WELWYN HATFIELD COUNCIL – DEVELOPMENT CONTROL
DELEGATED REPORT

APPLICATION No:	S6/2007/0421/LB
------------------------	------------------------

The proposed development would involve the demolition of an existing single storey prefabricated extension and the construction of a part single and part two-storey rear extension to accommodate a 13 new bedrooms and an associated accommodation. The proposed extension would be L-shaped around a courtyard area.

Drawing: Proposed Elevations

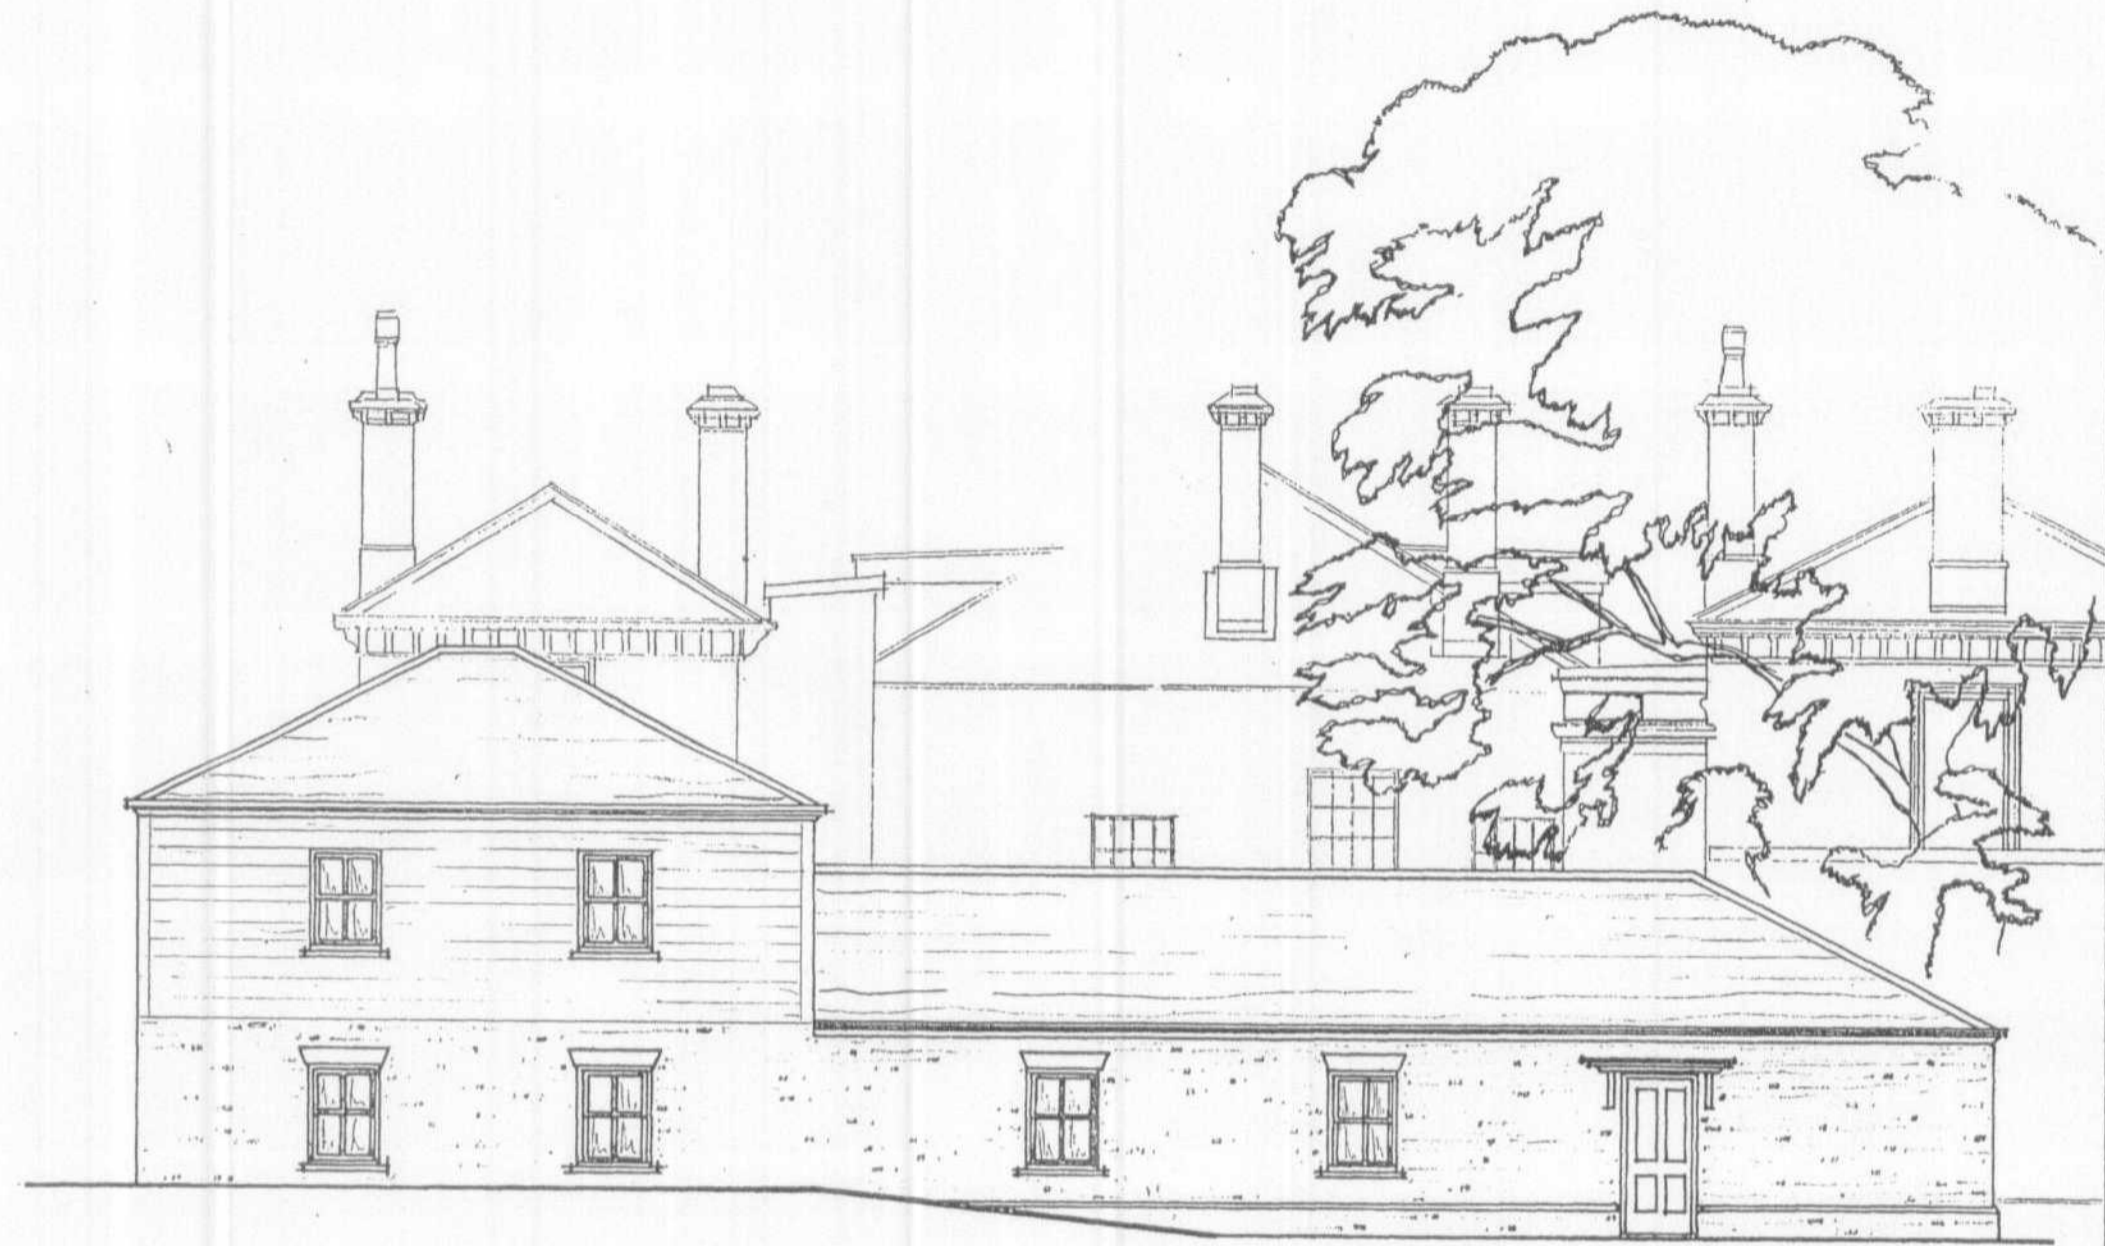
The Conservation Officer (Beams) – Amended plans were suggested which overcame the main concerns. Minor additional alterations have been requested to alter the window heads and arches to be brick rather than haddenstone and this alteration is to be conditioned.

- 2) The western elevation of the building has an imposing Italianate character, which is considered to be an important feature of the building and its listing. The proposal has been amended to respect existing western elevation by not having a large structure adjoining the western side of the building. The proposed dwarf brick wall and railings to the west would separate the Listed Building from the proposal and allow the main building to remain the dominate feature. The first floor areas of the proposal would be timber clad to break up the appearance of the proposed building, ensuring that it would not appear overly dominant. From the front of the building the proposed development would not be viewed and would not affect the appearance of the existing building. To the east of the site the existing building does not have as great importance as the western elevation. When viewed from the east the proposed development to would appear subordinate to the main building and would only be connected by a single storey link, which is considered to be acceptable. The proposal would therefore comply with Policy R25 of the Welwyn Hatfield District Plan 2005.

1. C.2.2 – Time Limit Full Permission (Listed Buildings)
2. C.5.1 – Material to be submitted
3. Notwithstanding the details on the approved plans, full details of amended elevations showing brick headstones and arches are to be submitted and approved in writing. Notwithstanding the provisions of the provisions of the Town and Country Planning, General Permitted Development) Order 1995 (or any Order revoking and re-enacting that Order with or without modification) no additional windows or similar openings shall be constructed in the flank elevation of the original dwelling and extension hereby permitted except for any which may be shown on the amended drawing(s) to be approved after the approval of this application.

Date: January 2007  
Drawing: Proposed Elevations  
Scale: 1:100  
Ref: Final Design - dwg 3

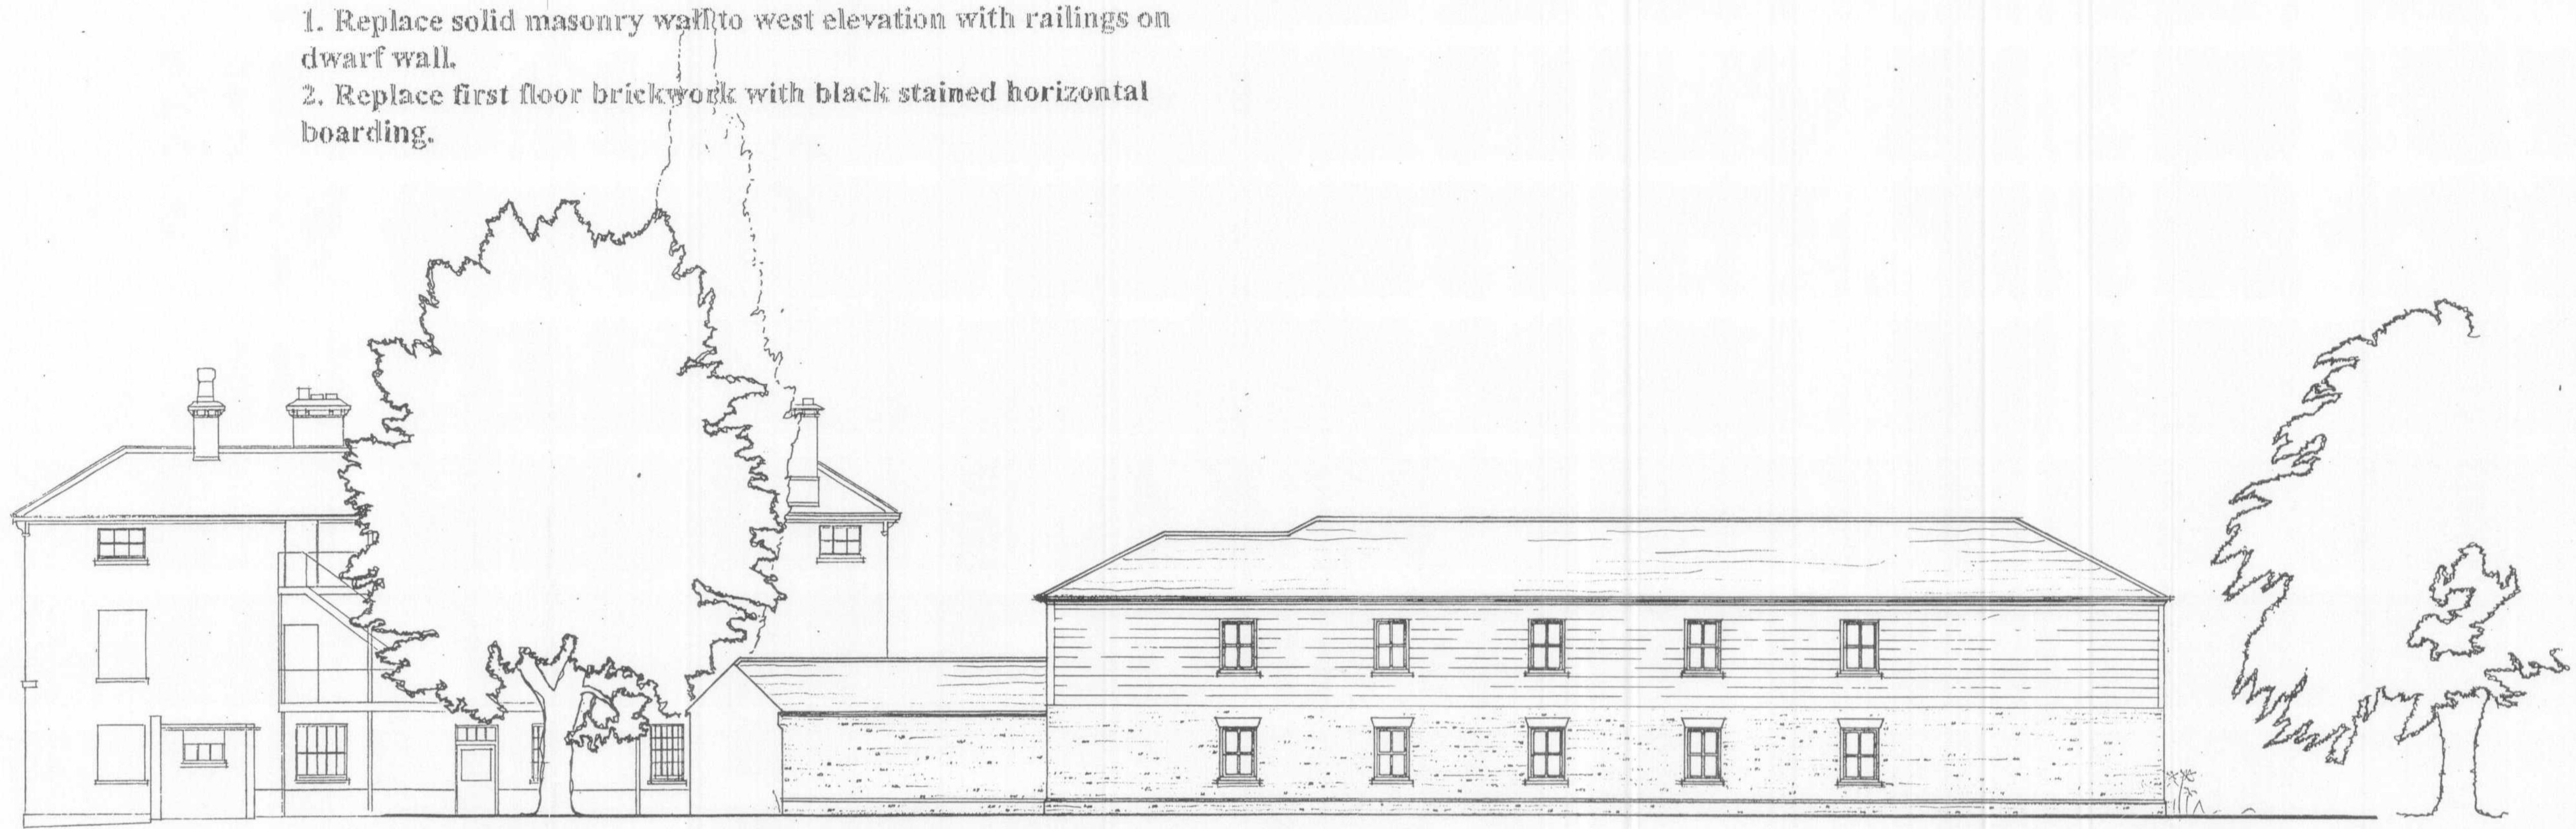
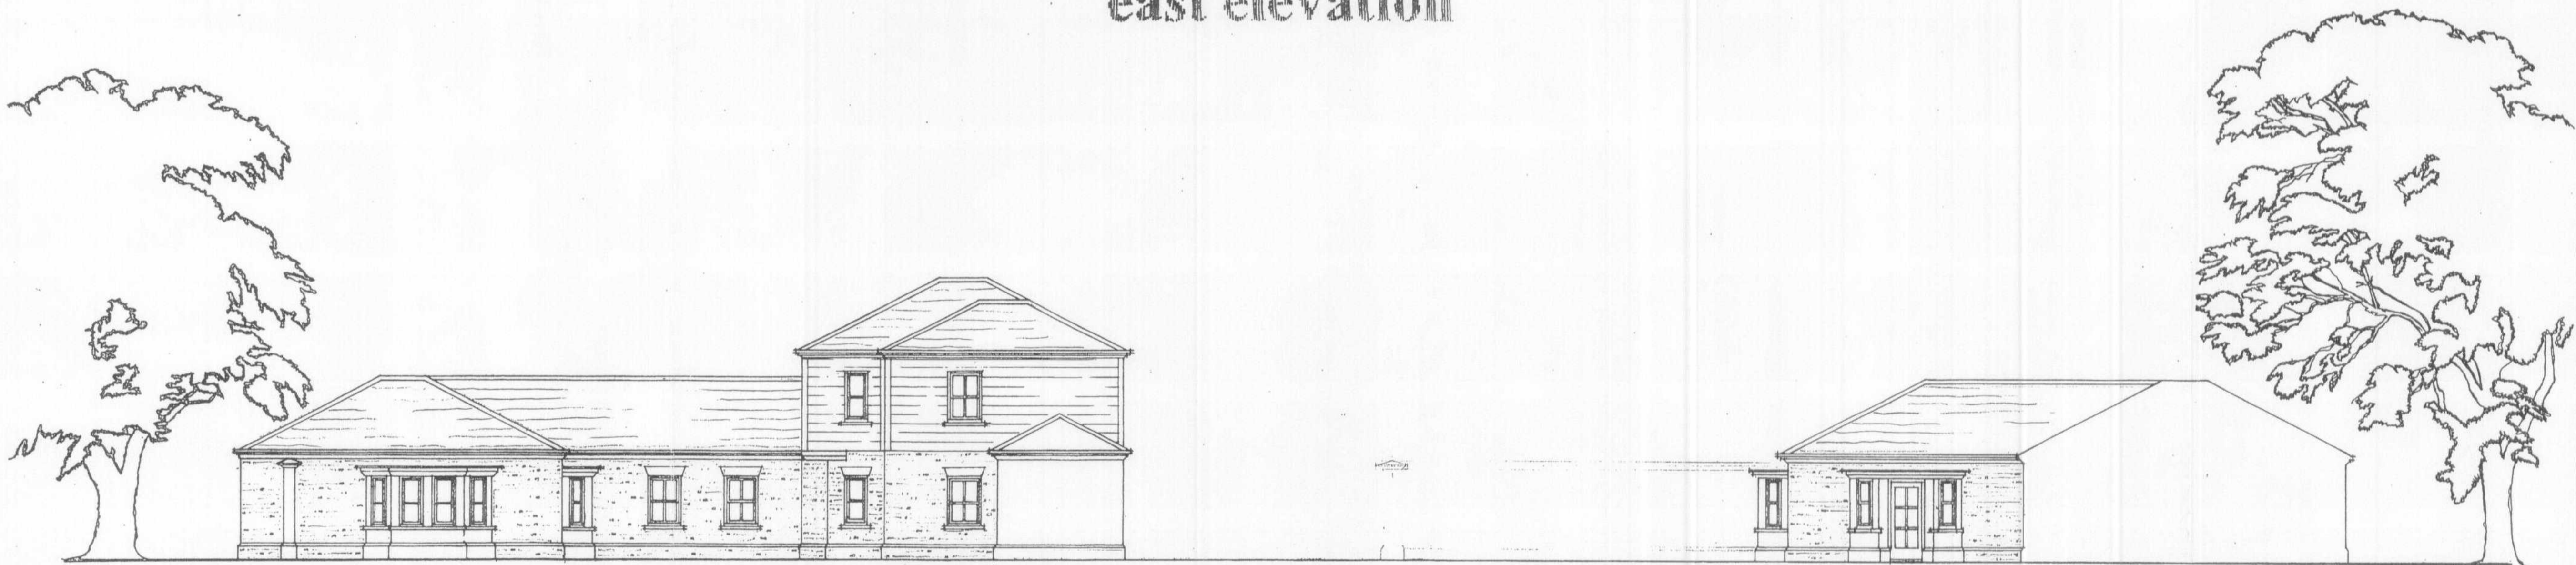
- 4) The only nearby adjacent properties lie to the east of the application site within Lysley Place. These properties sit on a higher ground level and are separated by a tall brick wall. The eastern flank boundary of the plot is splayed so that the proposal's distance from this boundary would increase with depth. Where the proposal would adjoin the existing building it would have a distance of 12.2m from the eastern boundary. To the rear elevation the proposal would have a distance of 16m from the eastern flank boundary. Although the proposed development would be set back from the nearest adjacent dwelling, any impact would be offset by the lower ground level, distance from the boundary and existing mature trees, which create a screen. The proposed development would be visible from the adjacent dwelling but would not be overly dominant or result in an adverse loss of light to this property. Although there may be a loss of view from this dwelling, this does not form a material planning consideration. The distance that would separate the proposal from the adjacent neighbour and the neighbour's overall outlook is considered to be acceptable. The distance from the nearest properties and screen of trees would ensure that the proposal would not result in any significant overlooking or loss of privacy.

The eastern flank boundary slightly differs between plans. The neighbouring property has stated that one of the plans does not show the land that is now in their ownership and resulted in a straighter boundary. The variation in boundary position has been taken into account within the assessment of the application and it would not alter the situation between the proposal and neighbouring property.
